Subject: Rezoning Petition Review

Date of Review: August 25, 2022 (*Revised September 16, 2022*)

Rezoning Petition #: 22-048

Location of Property: Approximately 182.71 acres located along the south side of I-485 South interchange, east of John Adams Rd and north of N Tryon St.

RZ-2

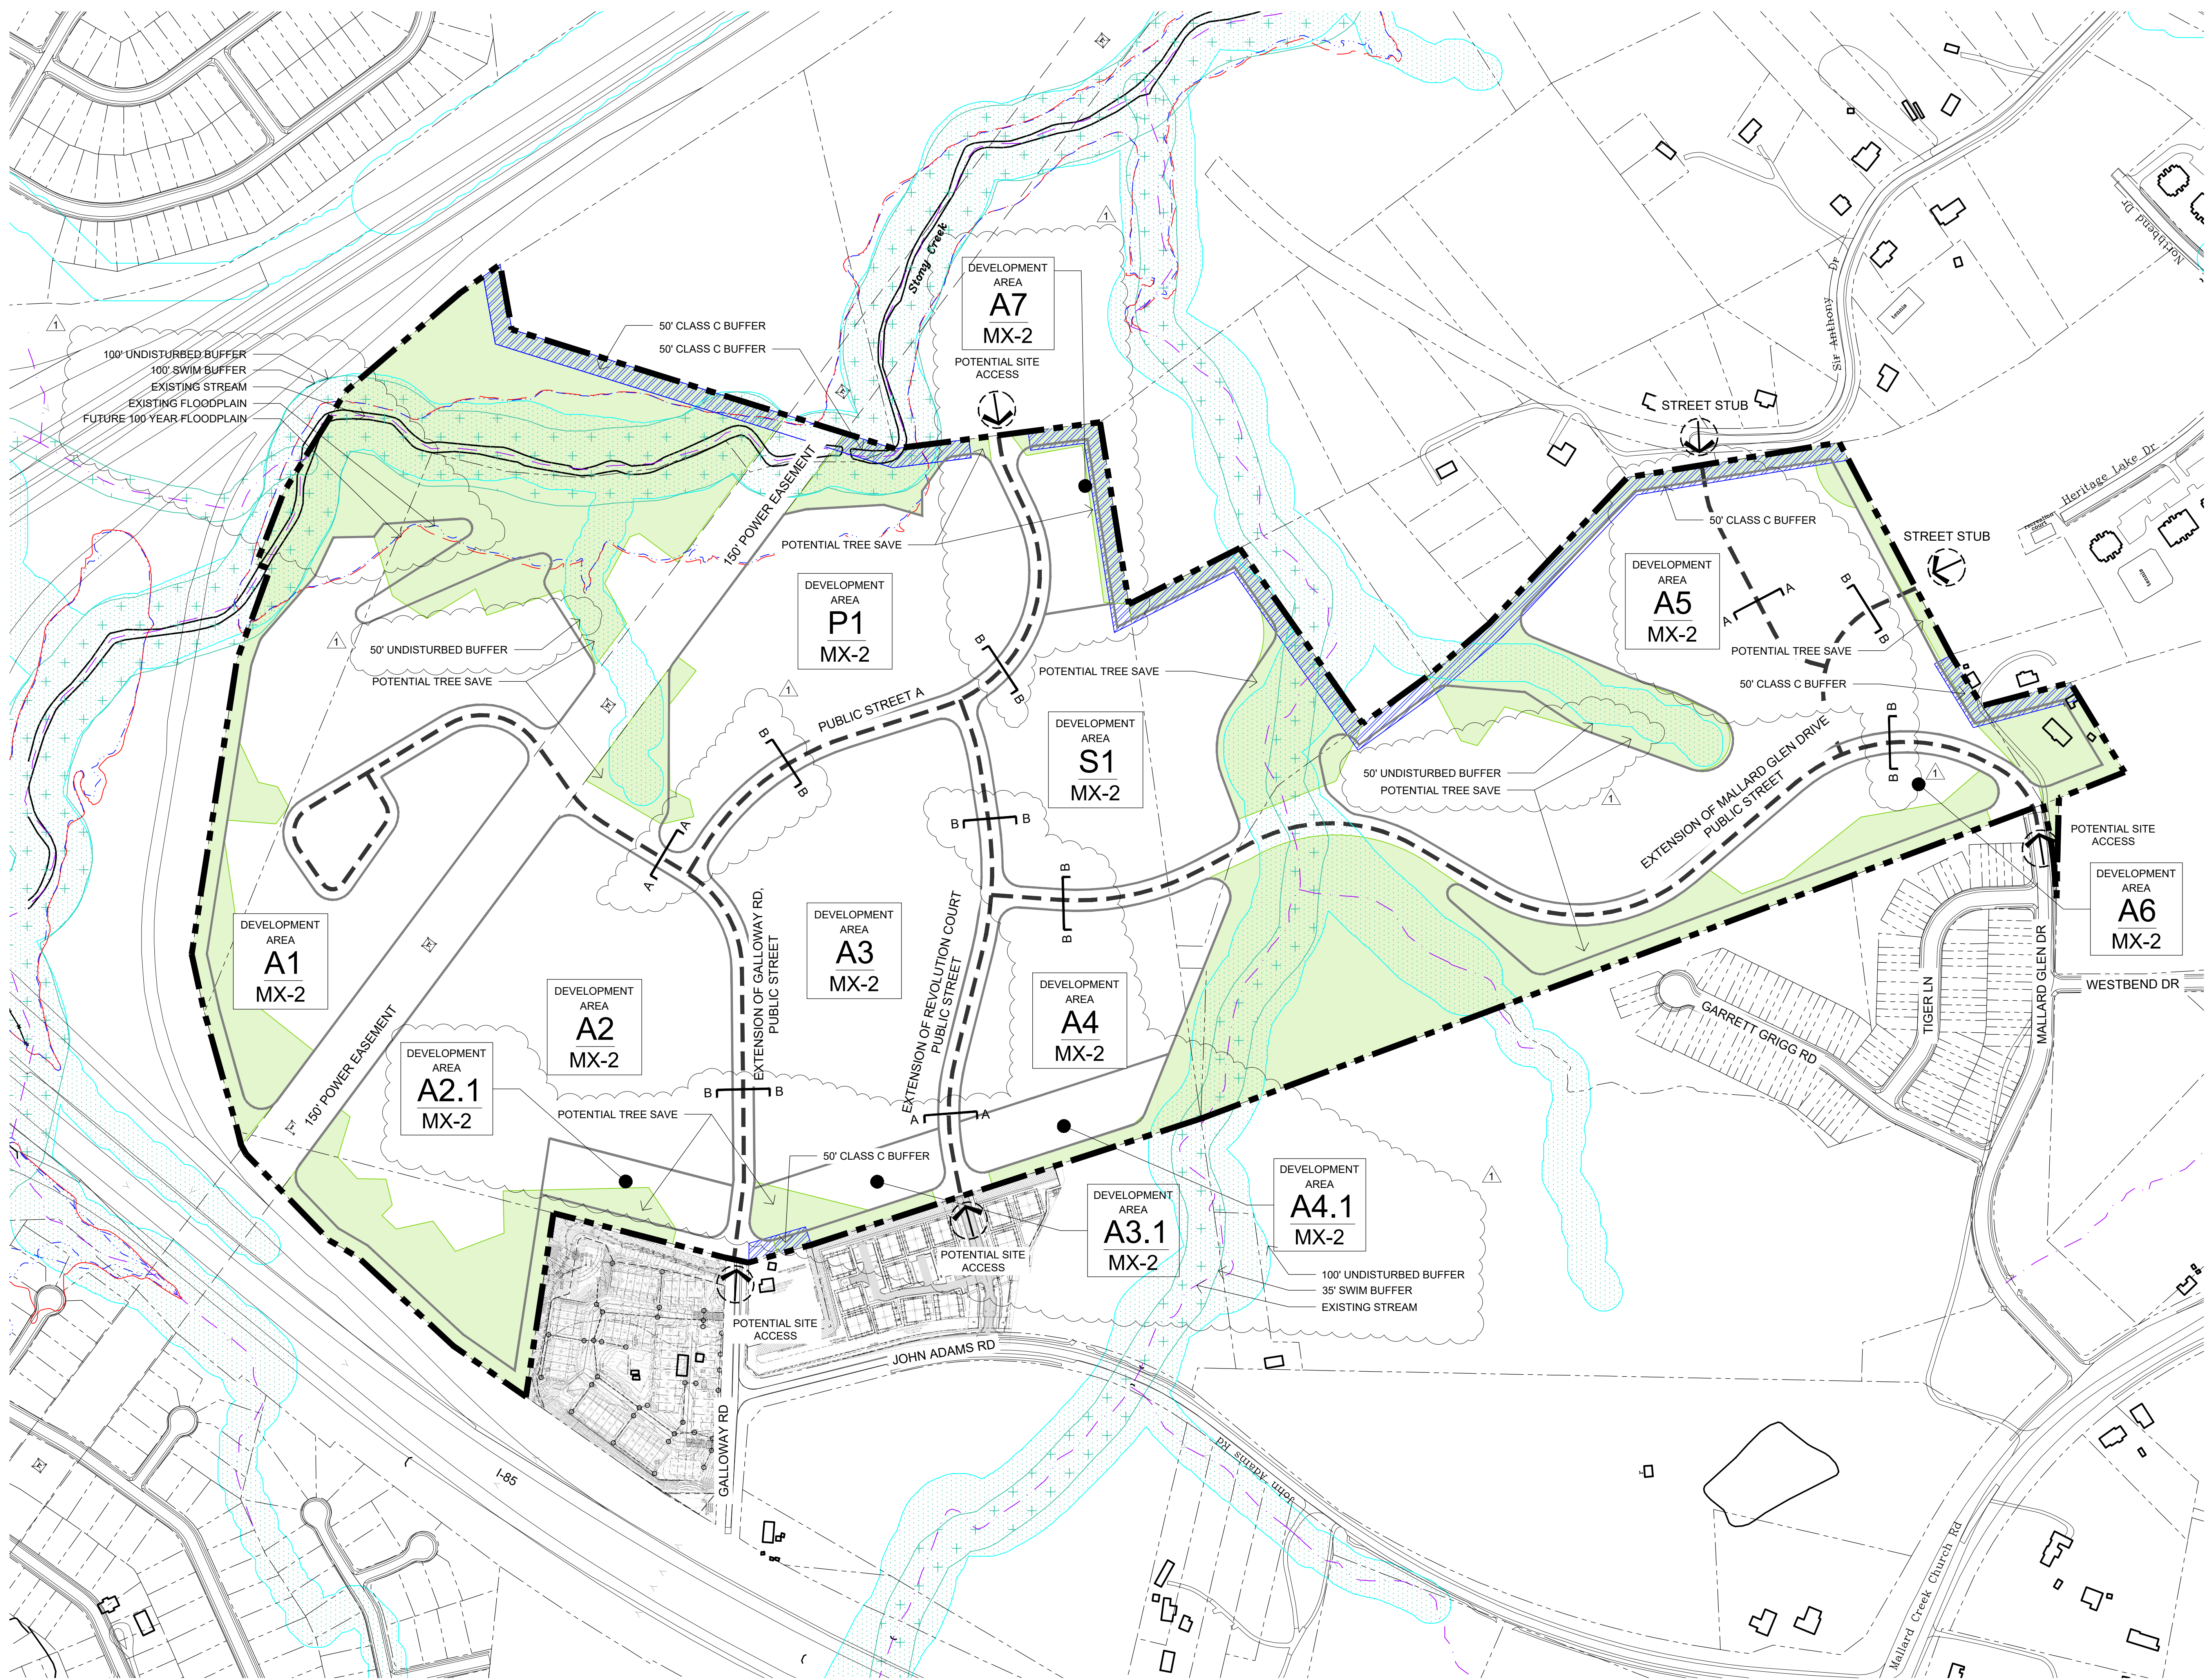
For the Yadkin Basin, petitioner is advised the 100' SWIM/PCSO Stream Buffers on the site may require the inclusion of 100% of the flood fringe area as additional stream buffer. Delineation of the additional stream buffer area may be deferred to the permitting process and is not required to be shown on the rezoning plan.

Please label stream buffers on the plan sheet and include the following note under *Environmental Features*: Development within any SWIM/PCSO Buffer shall be coordinated with and subject to approval by Charlotte-Mecklenburg Storm Water Services and mitigated if required by City ordinance. Petitioner acknowledges intermittent/perennial stream delineation reports are subject to review and approval upon submission of development plans for permitting and are not approved with rezoning decisions. The existing pond on site may require a buffer depending on results of the delineation report.

Due to revisions (9/16/22): No additional recommendations are needed at this time.
